**EL PASO COUNTY**

February 2, 2018

**Subject: Forest Lakes Phase II PUD Development Plan/Preliminary Plan (PUDSP-18-001)**

3
10 COUNTY TRAIL- STANDARD TIER 1 DETAIL

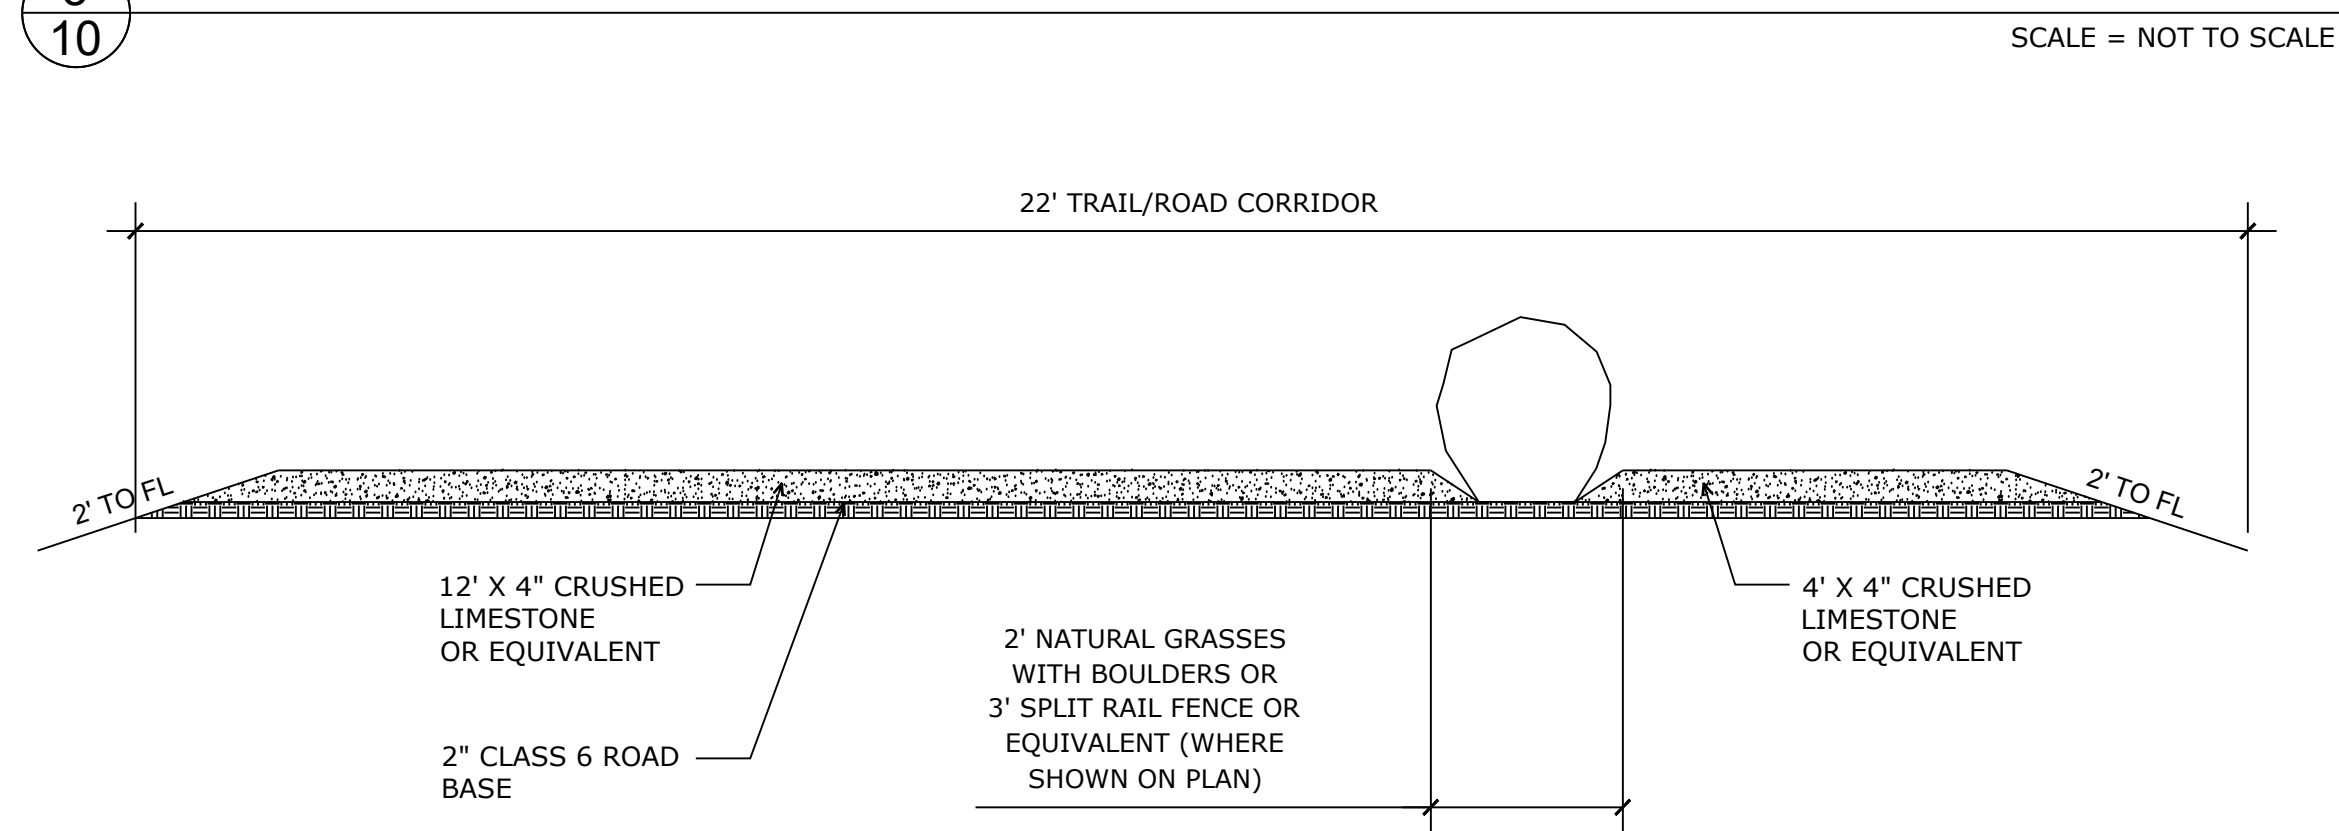
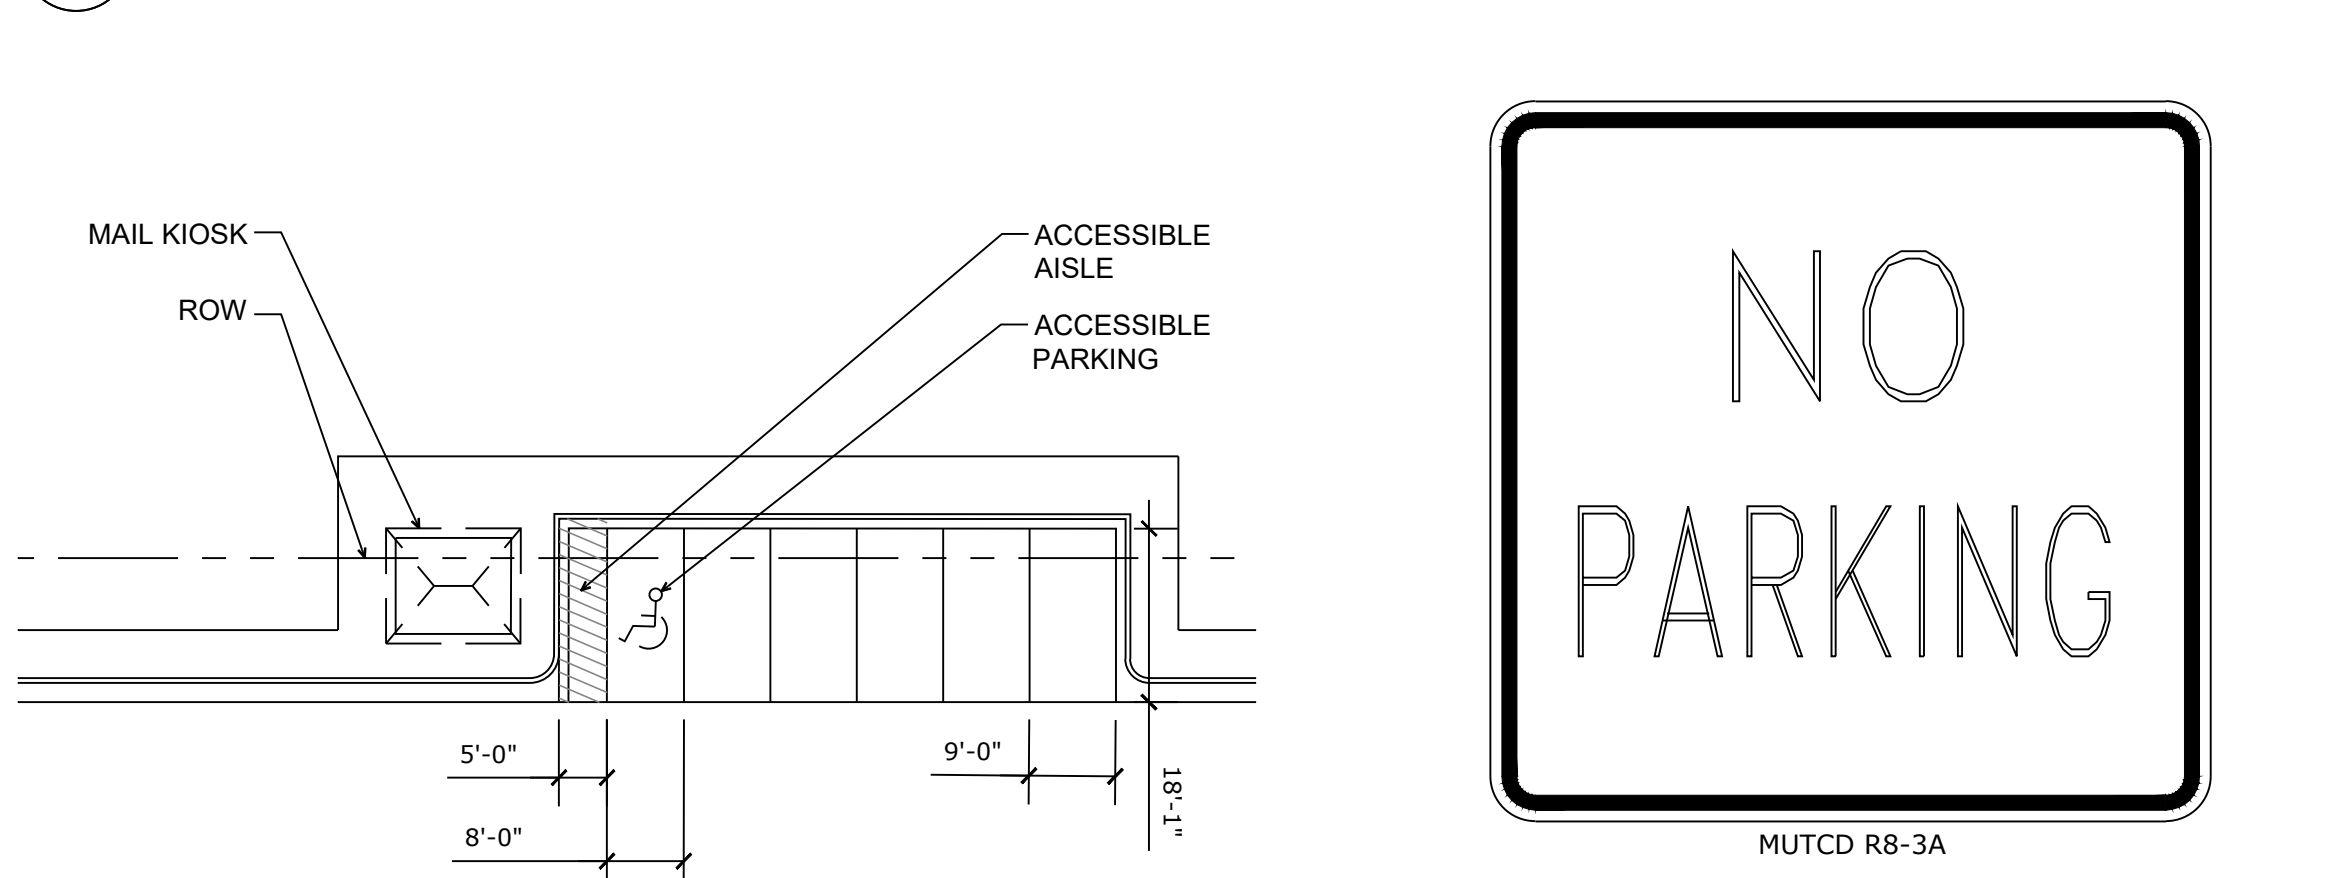
- Trail plans shall be submitted to and approved by County Parks prior to construction.
- The trail shall be constructed to Tier 1 standards for a primary regional trail.
